Pls add to the file and label 'Agent agreement to pre-commencement planning conditions – drainage and trees'

Have received below comments (see email) from our Drainage Advisor.

Thank you for reconsulting us on this application. The information submitted is insufficient to avoid the need for pre-commencement conditions.

Attenuation tank using polystorm-r geomodular units trafficked areas

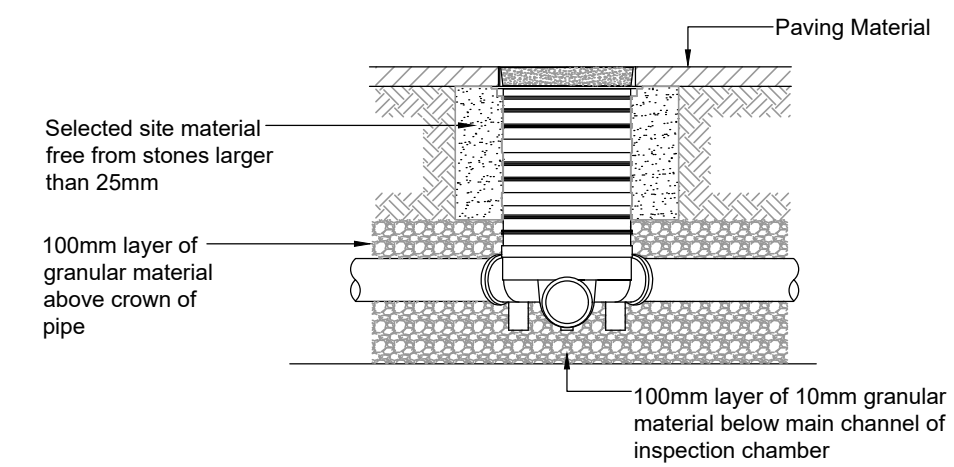
3. The calculations supplied do not include details of impermeable areas, the attenuation tank modelled or the flow control modelled. These details must be included in printouts to facilitate verification.

ELEVATION OF HEADWALL OUTFALL TO POND / SIDE OF DITCH

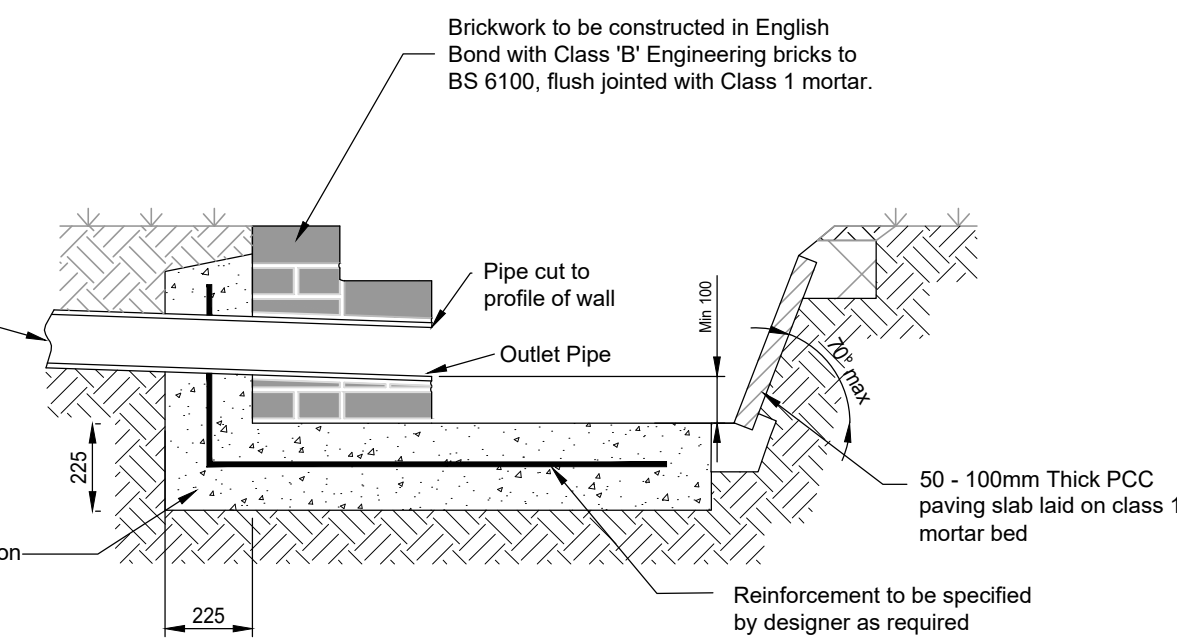
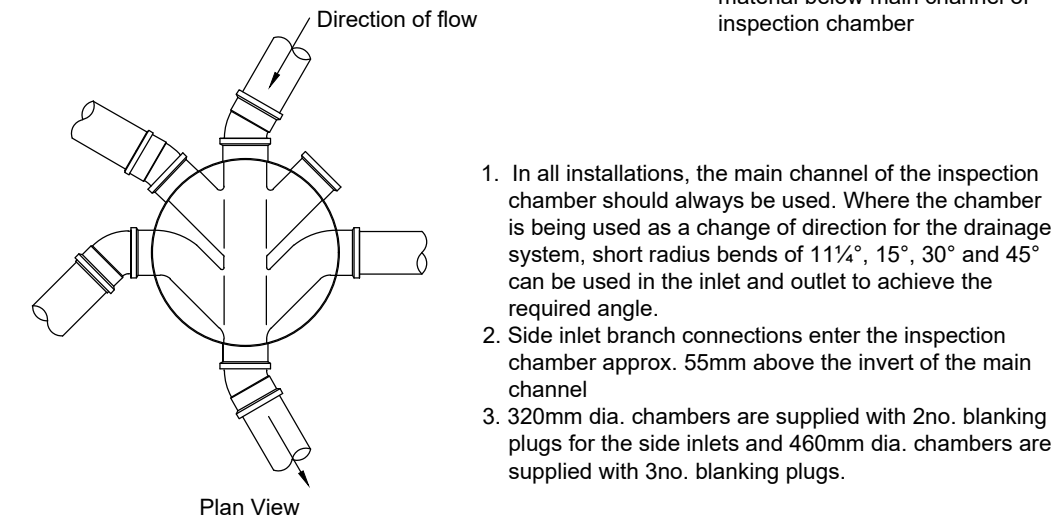
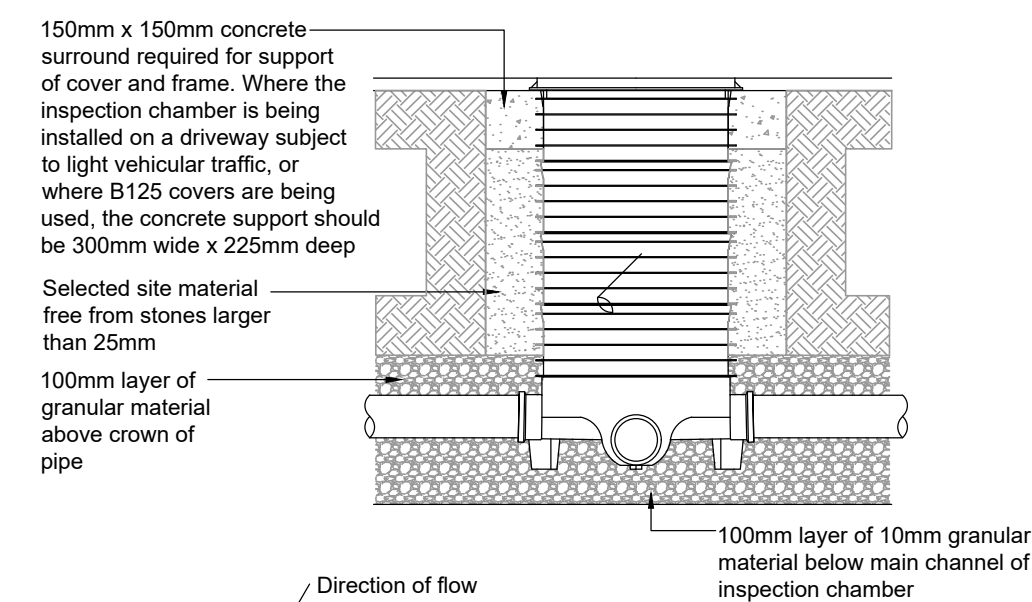
2. The drawing supplied shows a proposed connection to ordinary watercourse against the direction of flow, an alternative connection location is required.

PCENG D3

“The development shall not proceed until details have been submitted to and approved in writing by the Local Planning Authority for any proposals: to discharge flows to watercourses; or for the culverting, diversion, infilling or obstruction of any watercourse on or adjacent to the site. Any discharge to a watercourse must be at a rate no greater than the pre-development run-off values. No construction is permitted, which will restrict current and future land owners from undertaking their riparian maintenance responsibilities in respect to any watercourse or culvert on or adjacent to the site. “
